Our Ref: R/229/19/HH
Your Ref:

Town & Country Planning Act 1990 (as amended)
Town & Country Planning (Development Management Procedure) (England) Order 2015
Application for Planning Permission for Works or Extension to a Dwelling

Development Single storey rear extension
Location 15 Drewetts Close Rustington

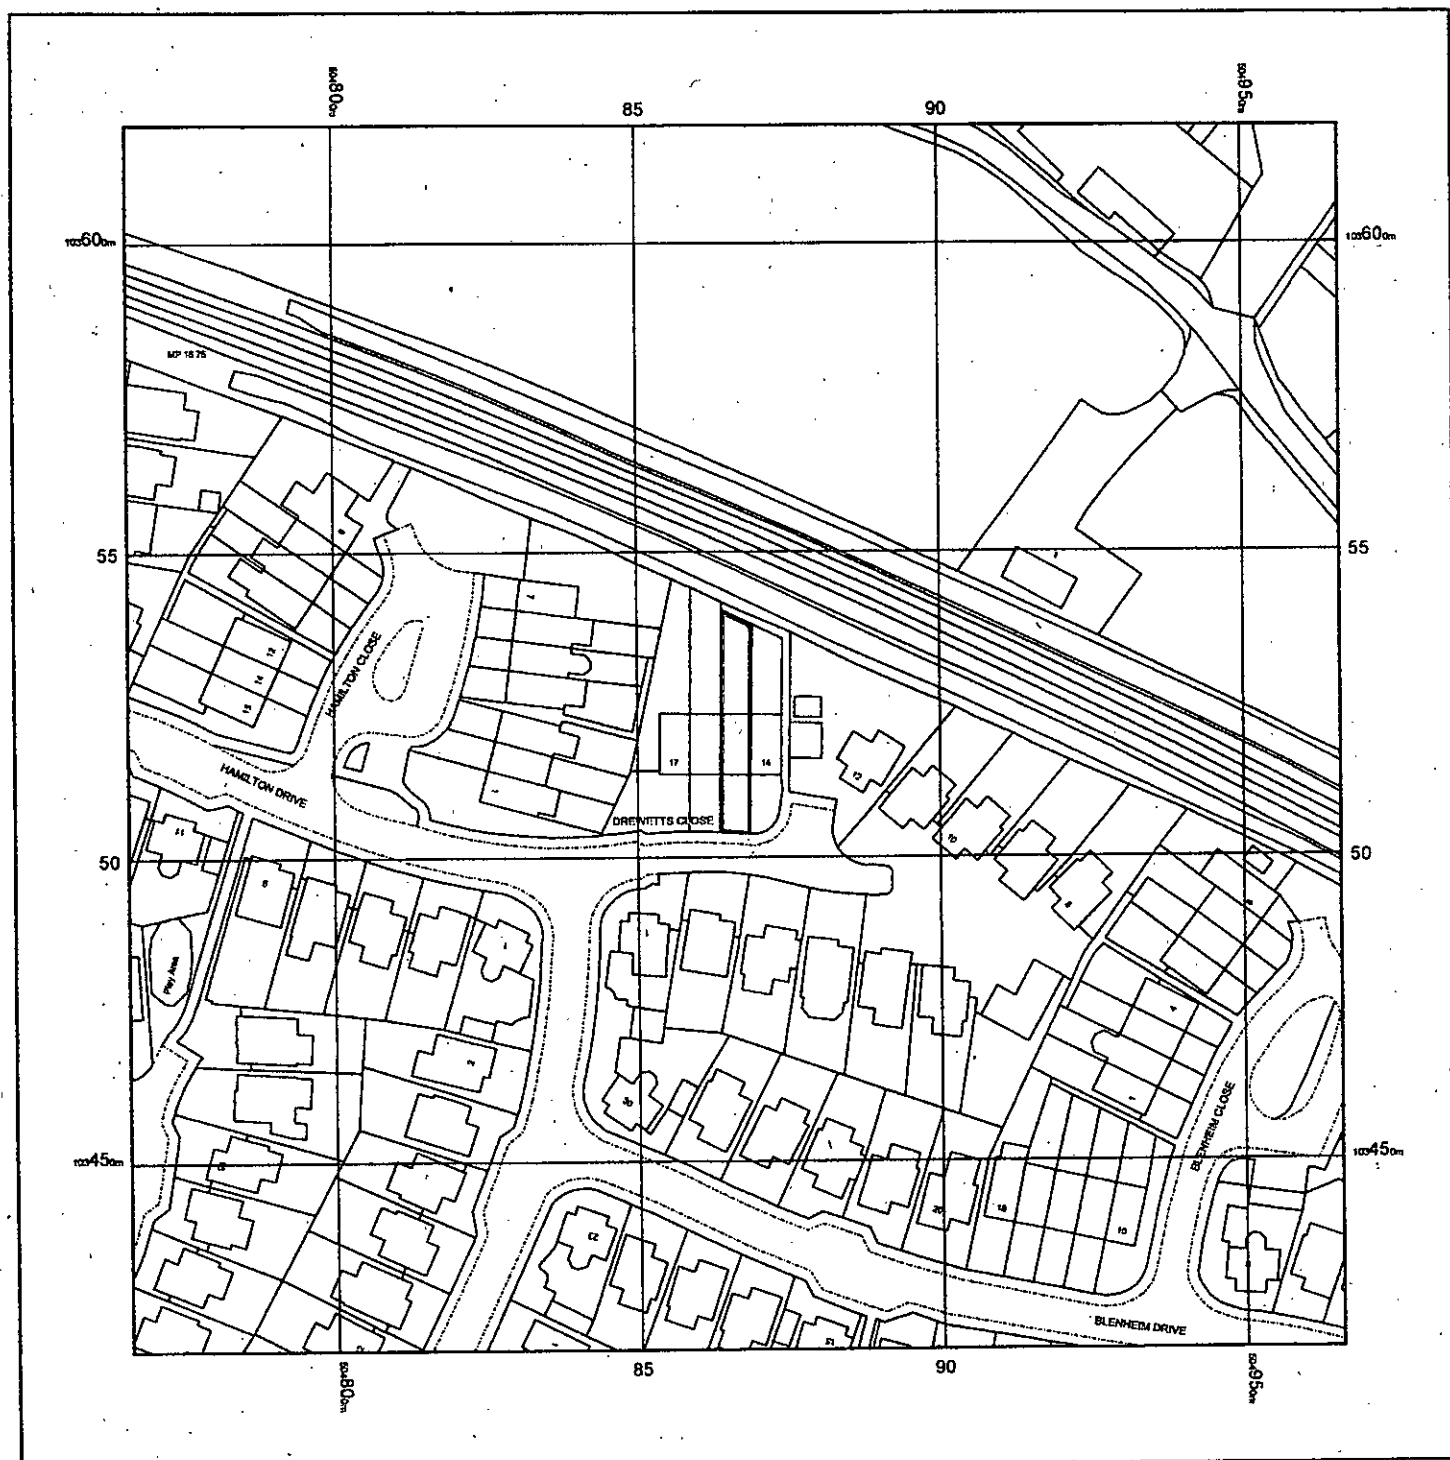
Block Plan Amend

Please provide a dimension to the rear boundary.
